Issue Specific Hearing 2 (ISH2): Onshore and Offshore Environmental Matters and dDCO

Hearing Action Points

Application by Mona Offshore Wind Limited for an Order Granting Development Consent for the Mona Offshore Wind Farm Project (EN010137).

Actions arising from **ISH2** held on **Wednesday 17 and Thursday 18 July 2024**.

Figure 1.3: Indicative location of Scallop Mitigation Zone.

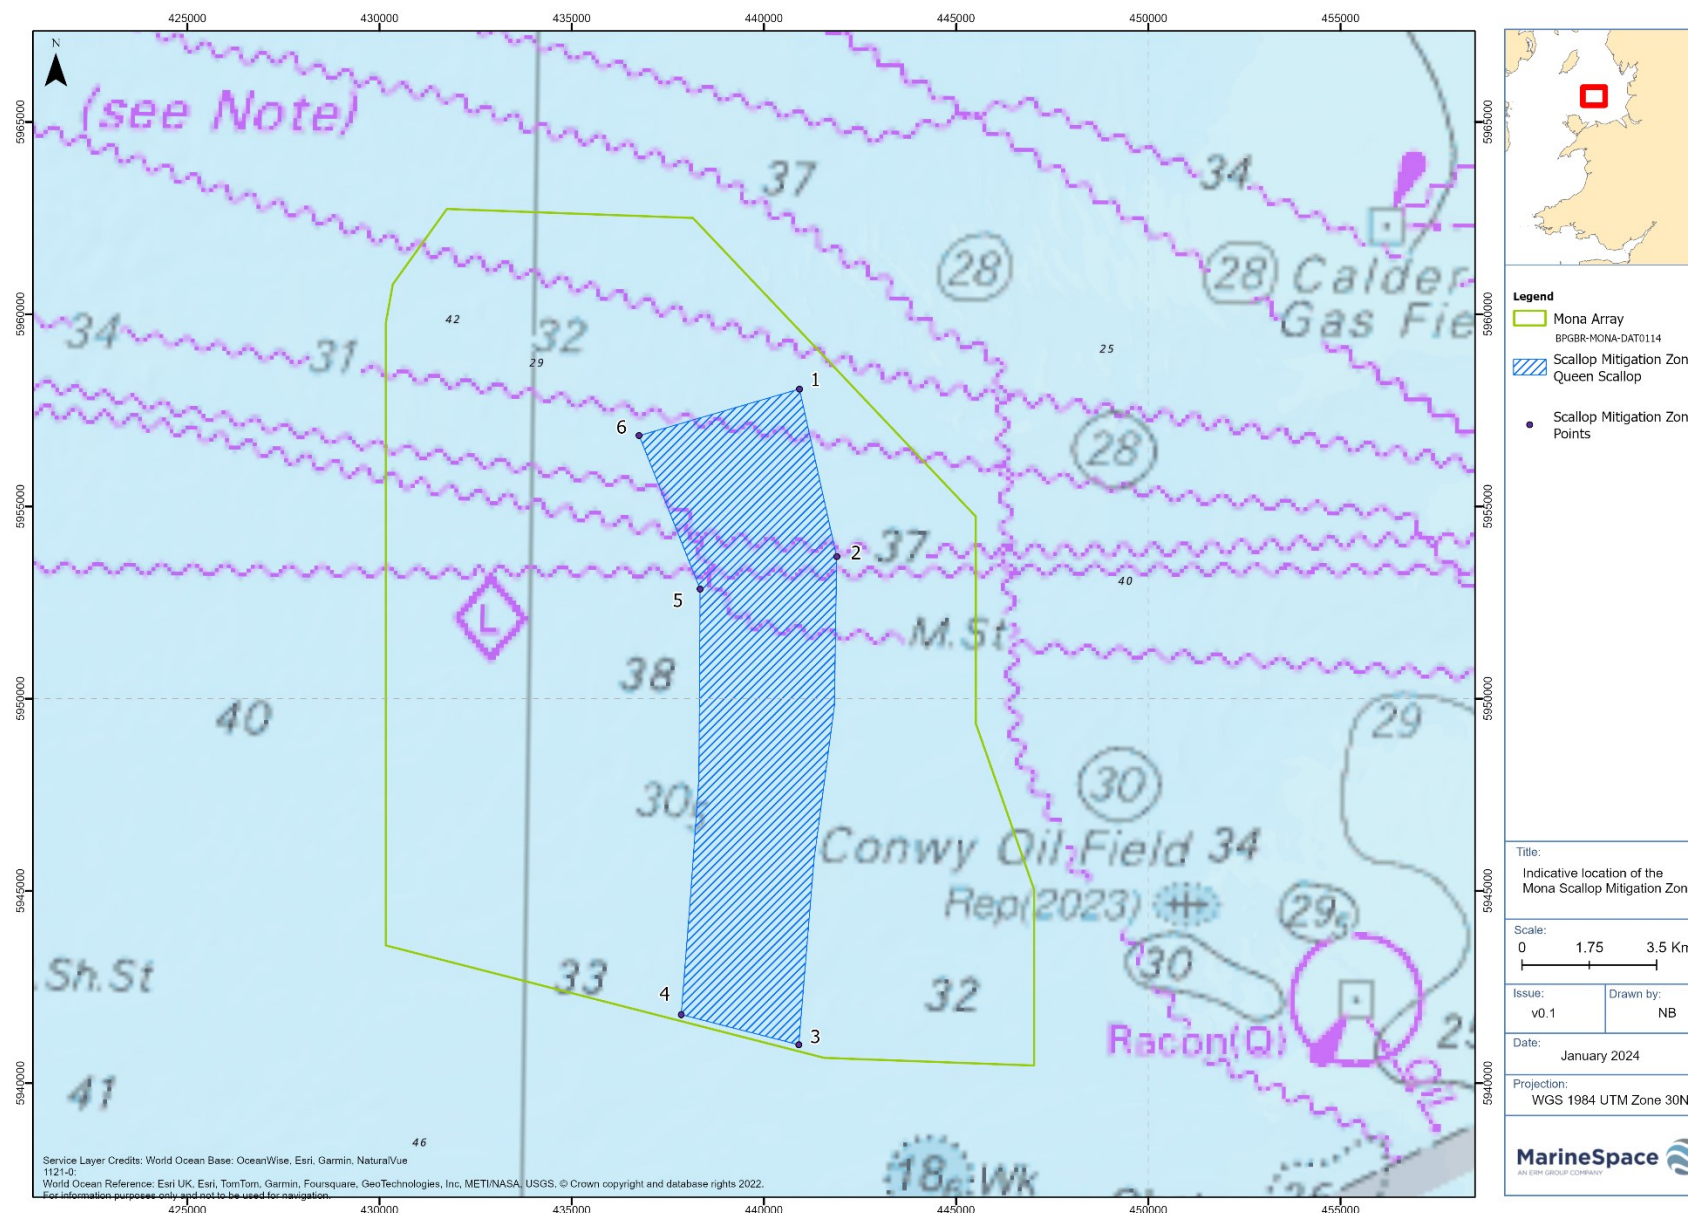
29	Advise if you have any remaining issues (pg 43) on the Proposed Development's impact on Cod following the Applicant's response to your Relevant Representation [PDA-008, RR-011.41].	NRW Advisory	Deadline 1
30	Confirm current size of Scallops area within the OL and compare with size of scallops mitigation area.	Applicant	Deadline 1
31	Review positive longitude co-ordinates in Table 1.3 of the Outline Fisheries Liaison and Co-Existence Plan [APP-199] with those in Table 3 in the DML which are negative.	Applicant	Deadline 1
32	Requirement 3(1): should the Civil Aviation Authority (CAA) be named? Refer consistently to Defence Infrastructure Organisation / Ministry of Defence. Requirement 3(2): should the CAA also be notified?	Applicant	Deadline 2
33	Should DML condition 15(5) also apply in the event of damage to the authorised scheme, by reference to condition 13(12)?	Applicant	Deadline 2
